CITY OF ALBUQUERQUE

**RE: Event Center
1611 Airtech Ct. SE
Grading and Drainage Plans
Engineer's Stamp Date: 05/14/24
Hydrology File: N15D017**

Based upon the information provided in your submittal received 05/15/2024, the Grading & Drainage Plans **are not** approved for Building Permit and Grading Permit. The following comments need to be addressed for approval of the above referenced project:

24001-RTW 2-B PROFILE

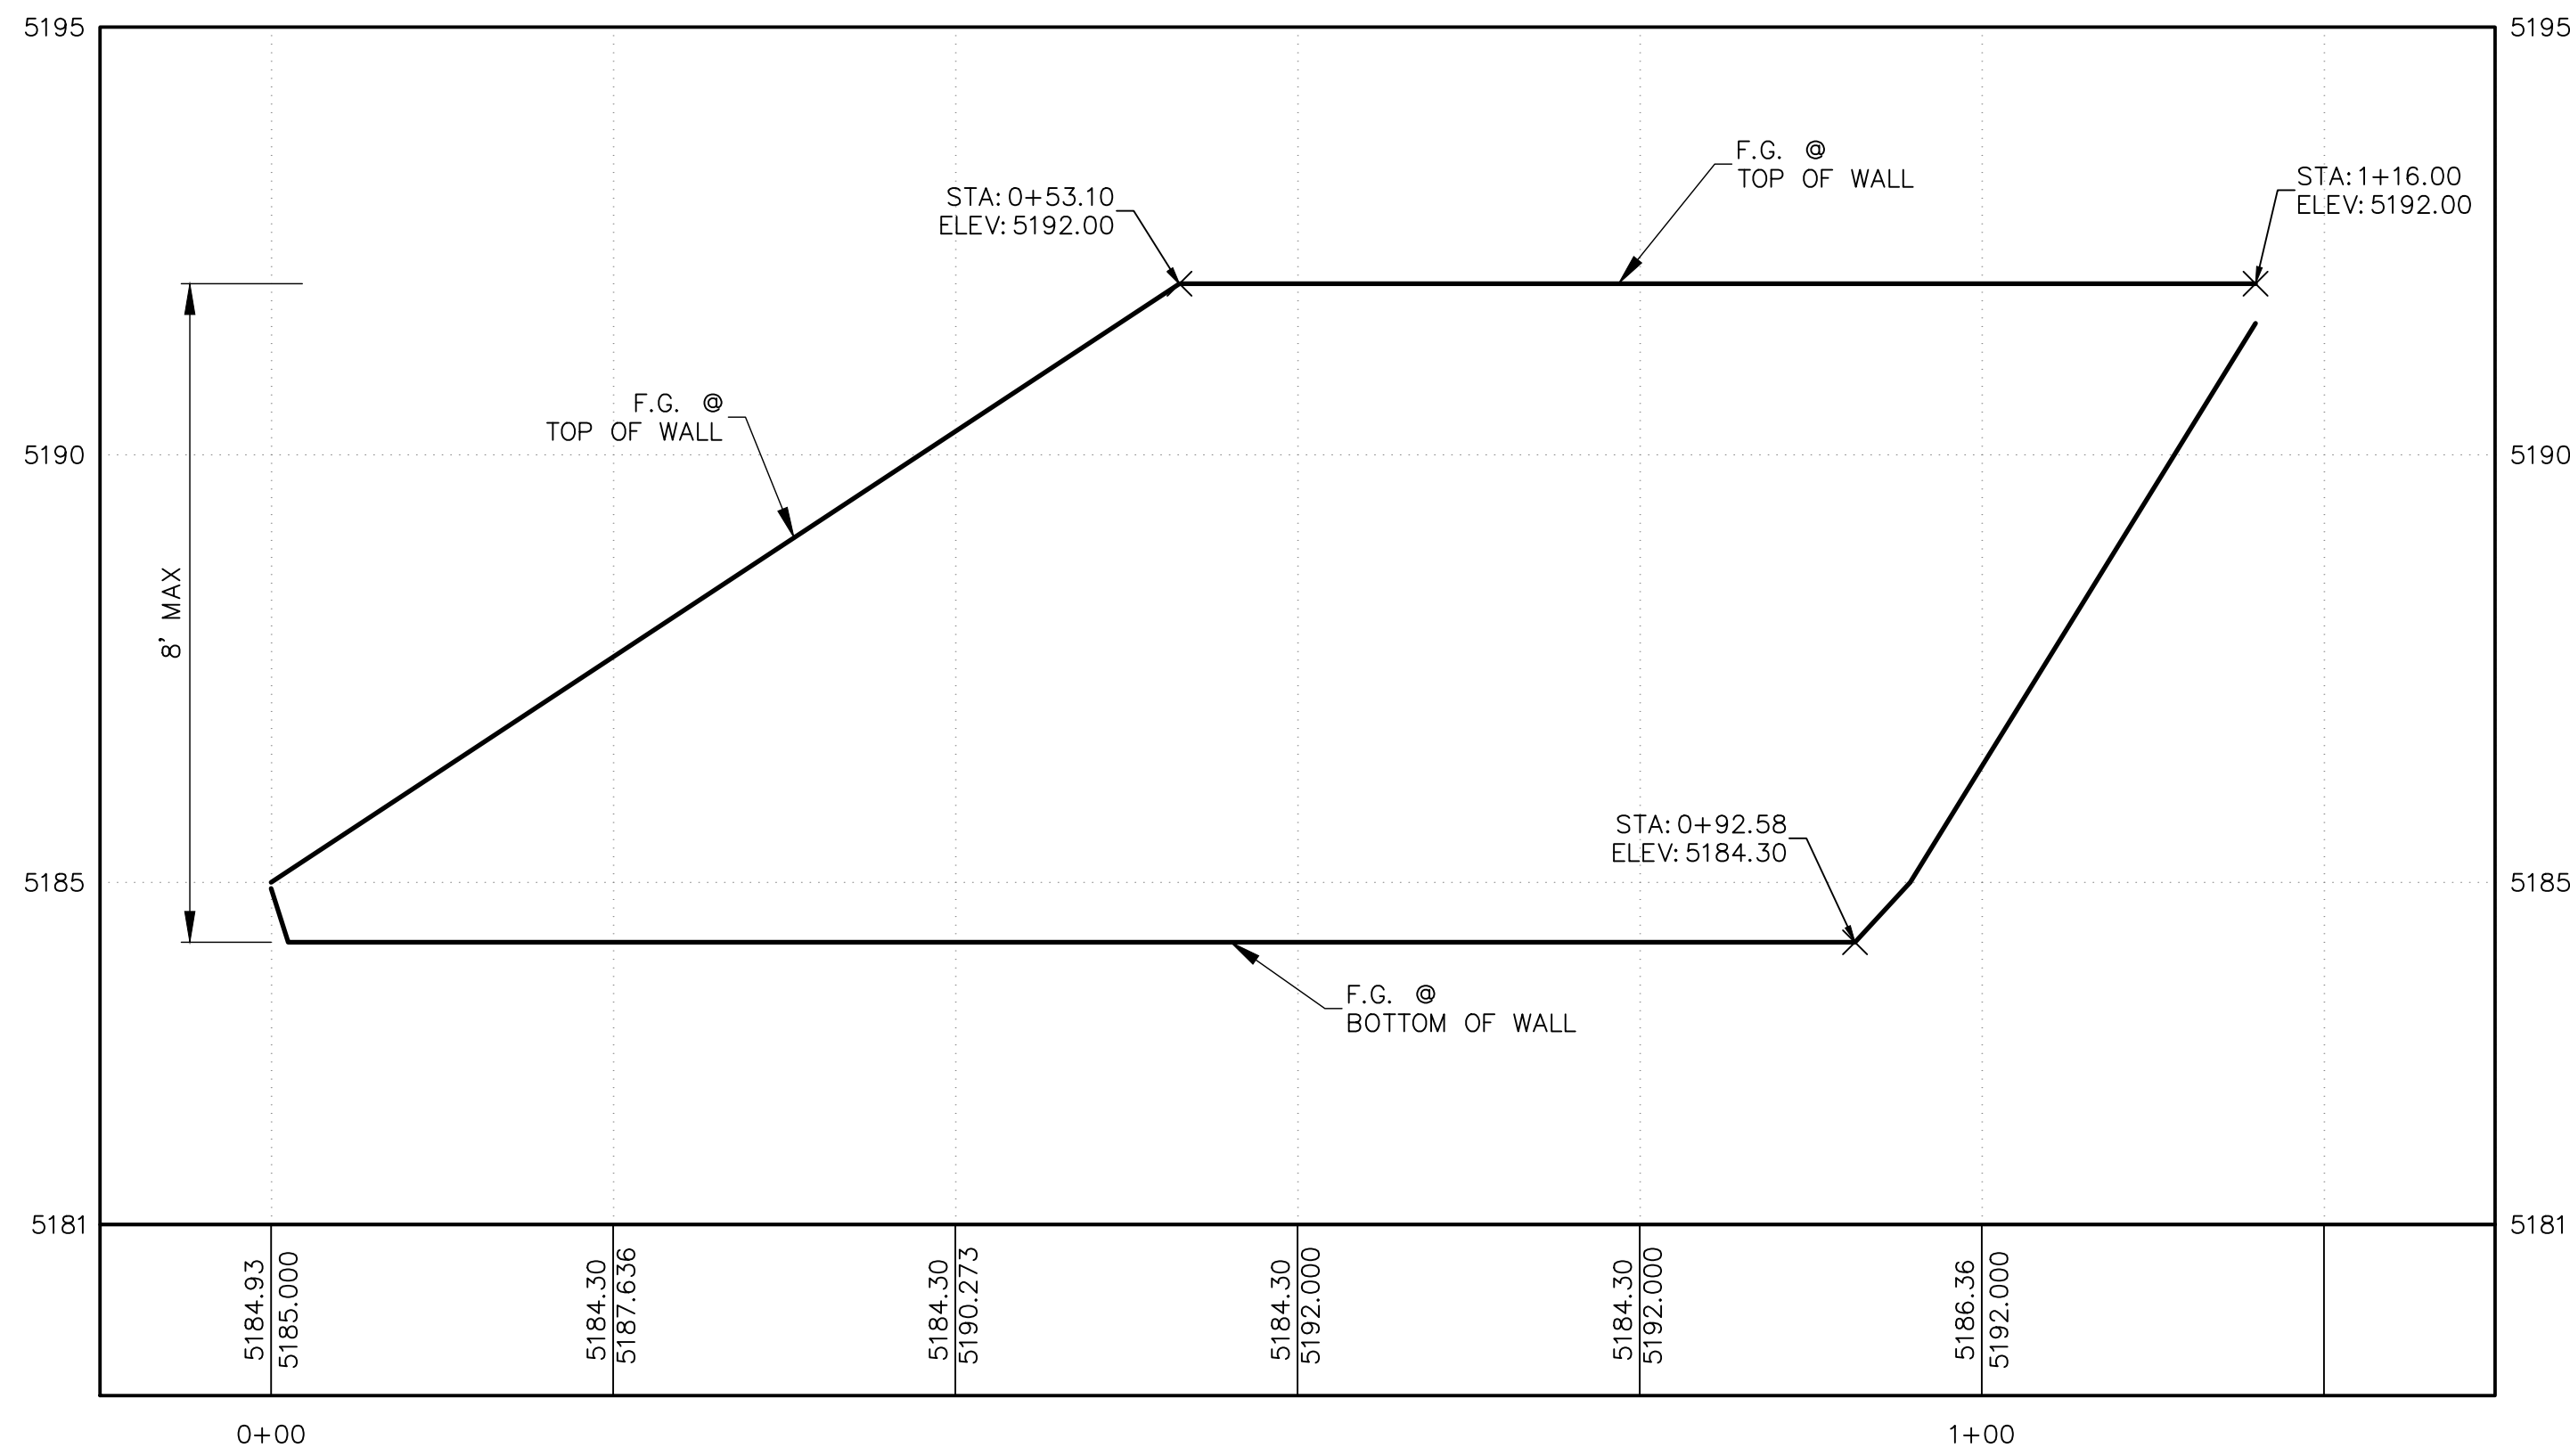
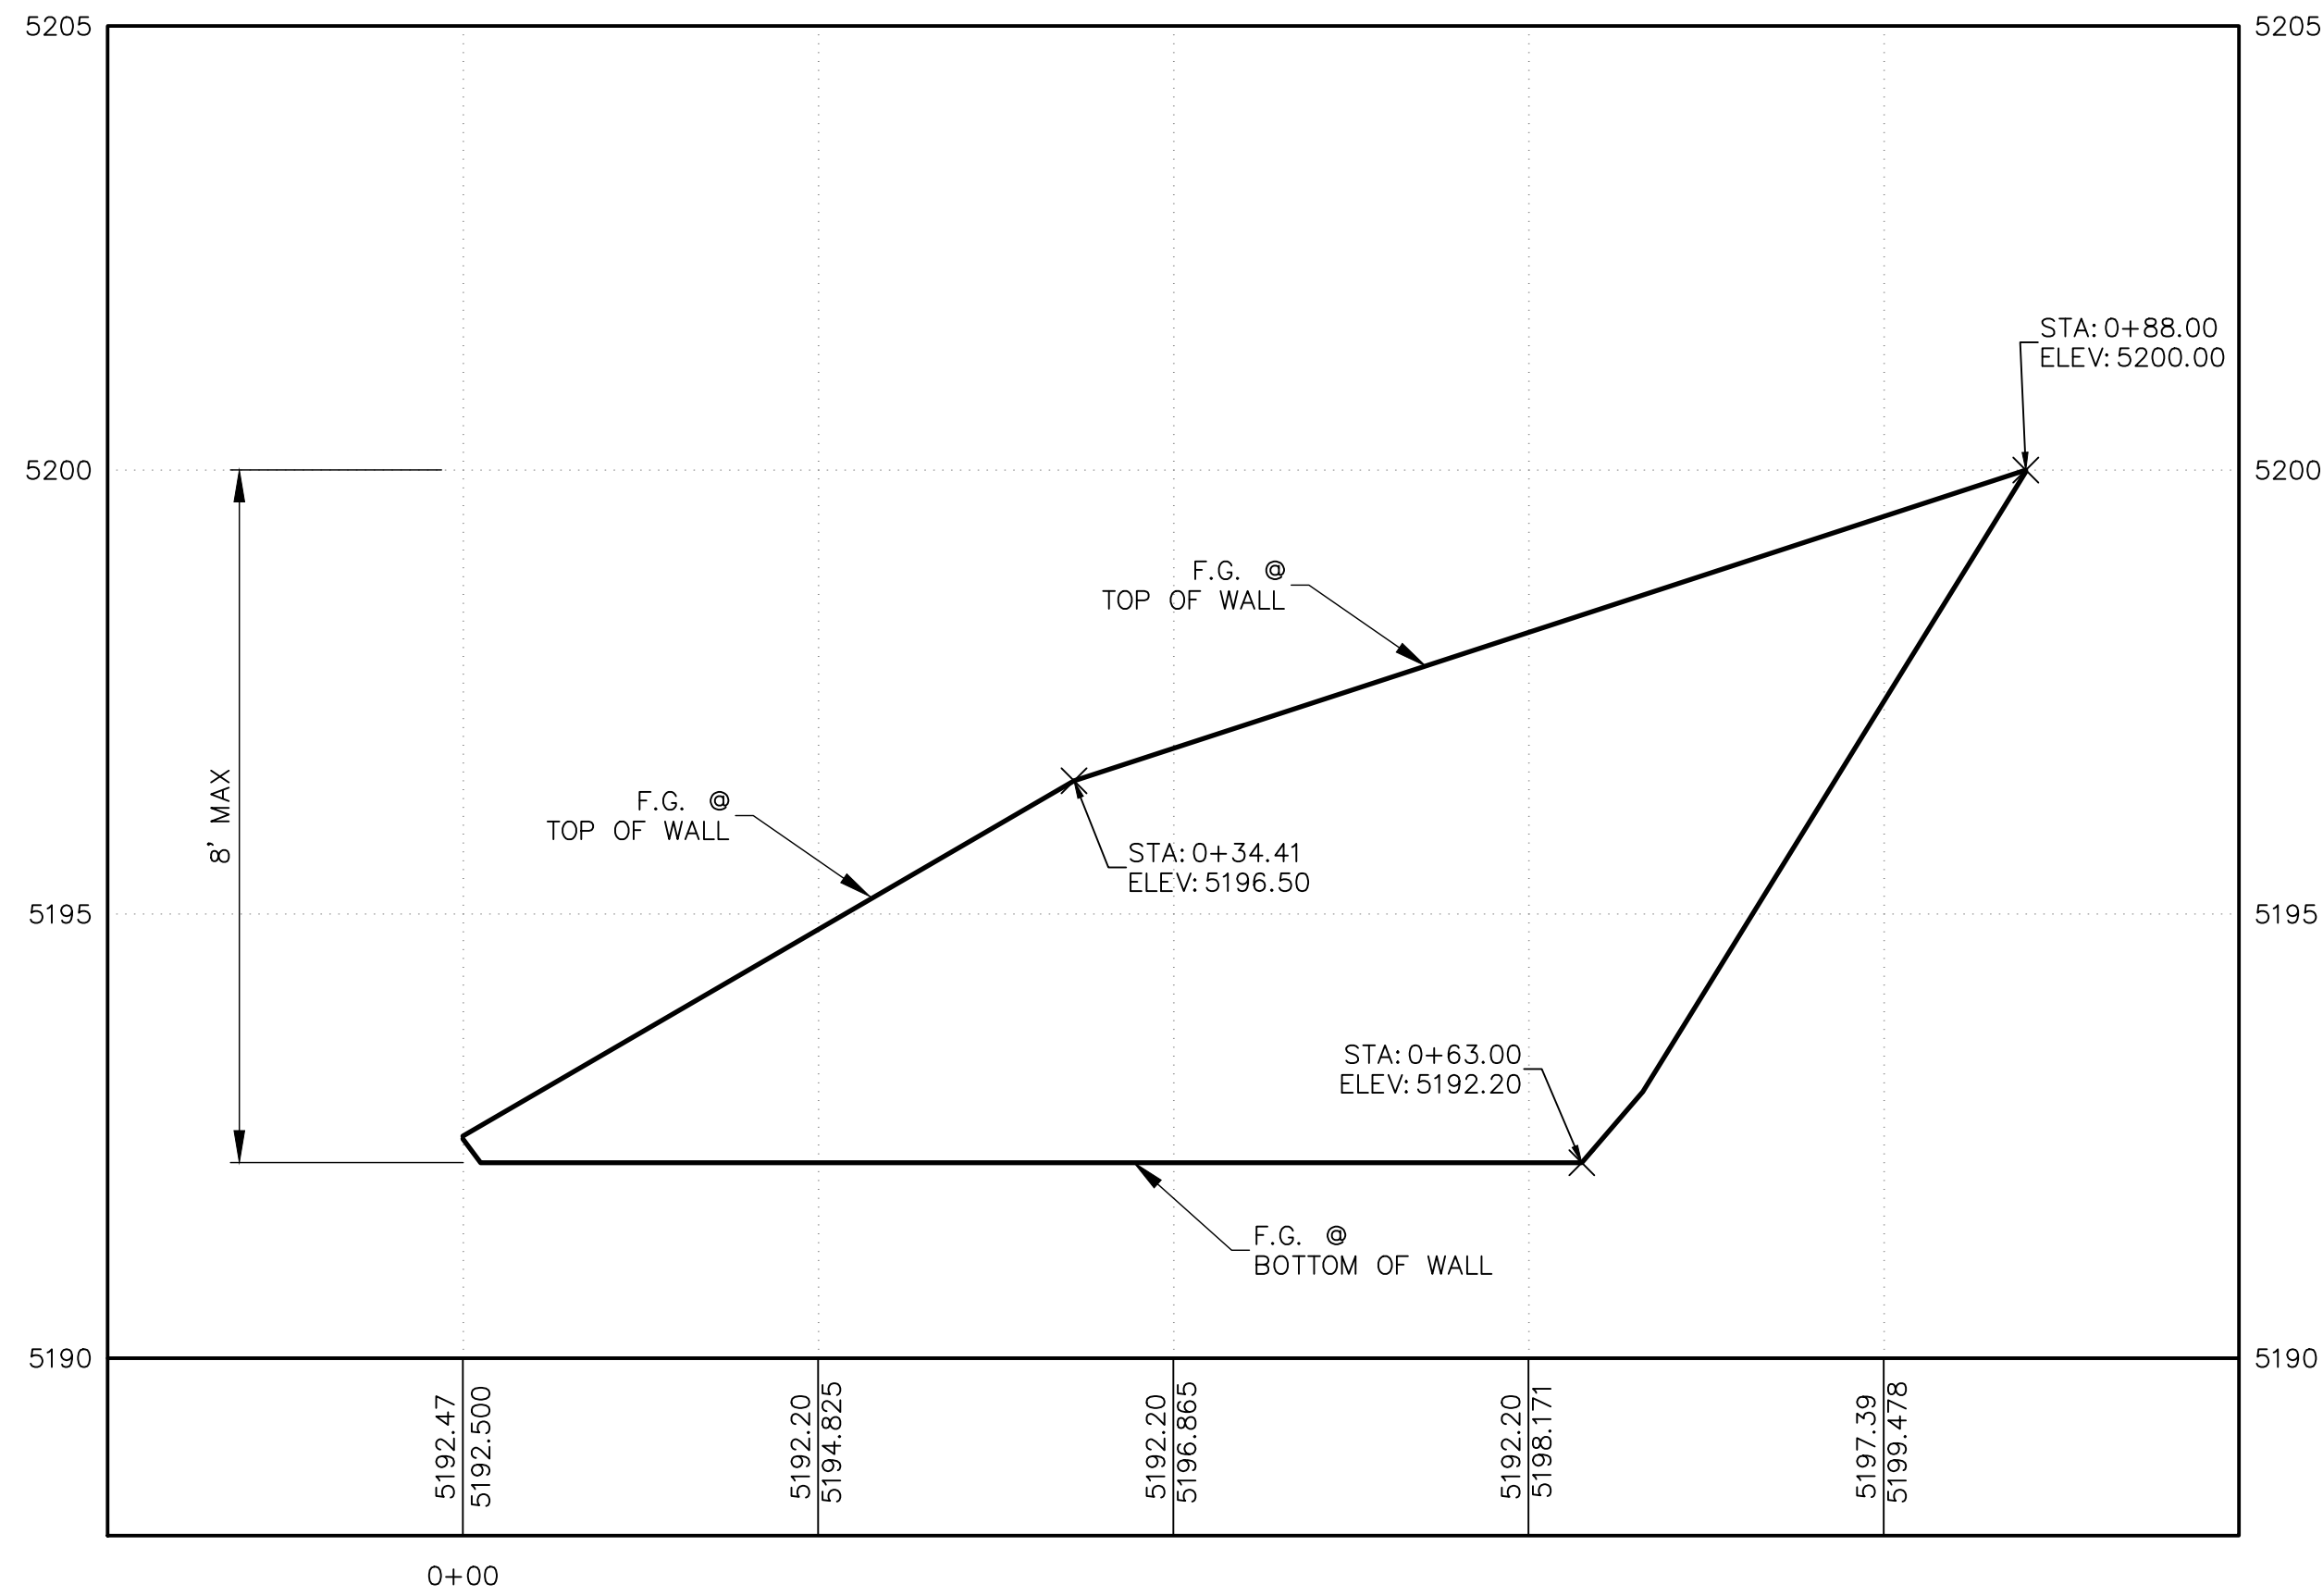
9. The retaining walls shown along the southern property line violates the IDO's maximum wall height of 8 feet in total height. These walls have a total height of 15 feet.
